**KIRKLEES METROPOLITAN COUNCIL
INVESTMENT & REGENERATION SERVICE**

DELEGATED DECISION TO DETERMINE PLANNING APPLICATIONS

Reference No:	2024/62/92324/E
Site Address:	21, Northfield Lane, Highburton, Huddersfield, HD8 0QT
Description:	Formation of basement to increase living accommodation
Recommending Officer:	Elenya Jackson

DECISION – REFUSED

BASEMENT/VOID FLOOR PLAN

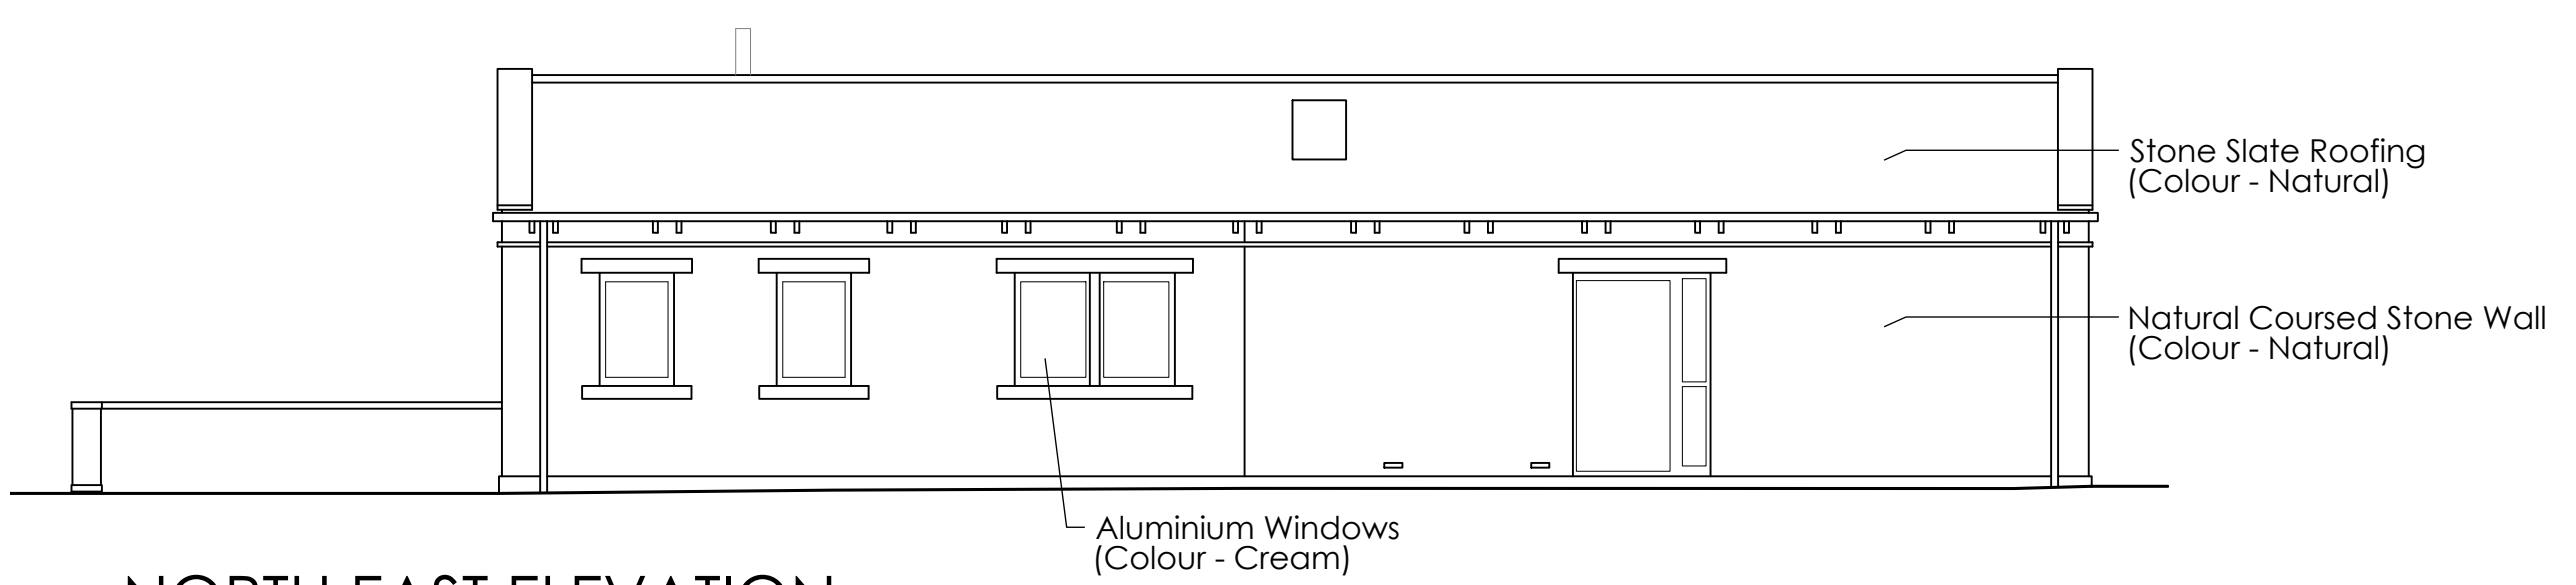
Alterations forming this application include the addition of three windows in the southwest elevation of the annexe and the creation of an undercroft/basement to the property.

Whilst the buildings replaced as part of the previous application for the building were not as large as that for which permission was granted by virtue of application 2017/90828, the replacement building was single storey. The resultant building the subject of this application would see the floorspace increase significantly, with other increases appearing to have also already taken place. The insertion of openings and the associated works would see a two storey building created in terms of appearance and also as a result of the physical works to the building. It is considered the extent of the works the subject of this application would see the building extended such that it would constitute disproportionate additions over and above that which could be considered to meet the requirements of policy LP57 / paragraph 154(c) of the NPPF.

The volume of the proposal in its current format would be 444.7m³. Having regard to the planning history of the site, extent of previous developments which have taken place and the scale and nature of the

development proposal the subject of this application it is concluded that the further development of the site, the subject of this application constitutes disproportionate additions over and above that of the original dwelling to which the outbuilding the subject of this application relates. The proposal is therefore concluded to constitute inappropriate development.

SOUTH WEST ELEVATION

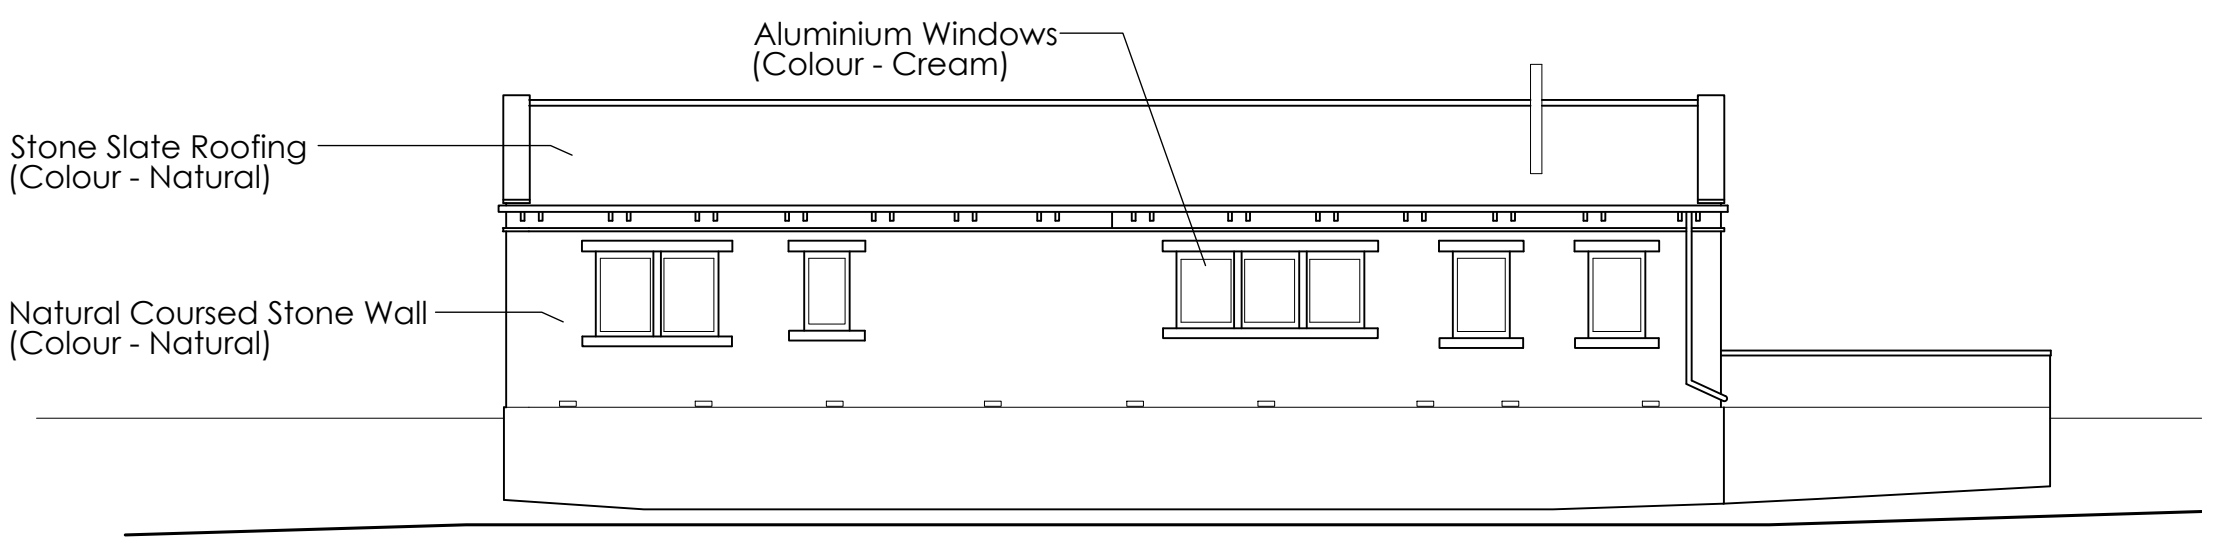
The addition of windows into the undercroft, and associated works, would be seen as an additional volume and in particular floor space which would result in a scale of development which could not be considered ancillary to the host dwelling. The resultant building would therefore appear both visually and functionally as a stand alone dwelling and would fail to accord with paragraph 154 C of the NPPF.

It is the case that when viewed in the context of the original development on site, and the justification for the previous approval, the additional volume increase would not be acceptable. The proposal would be allowing additional volume in the Green Belt, which would result in the proposal appearing as a two-storey structure when viewed from the West and in turn appearing as an additional dwelling on site opposed to an ancillary structure.

The additional windows would be located on the western elevation of the building and therefore would not raise any concerns regarding overlooking given the distance they would be sited from neighbouring occupiers.
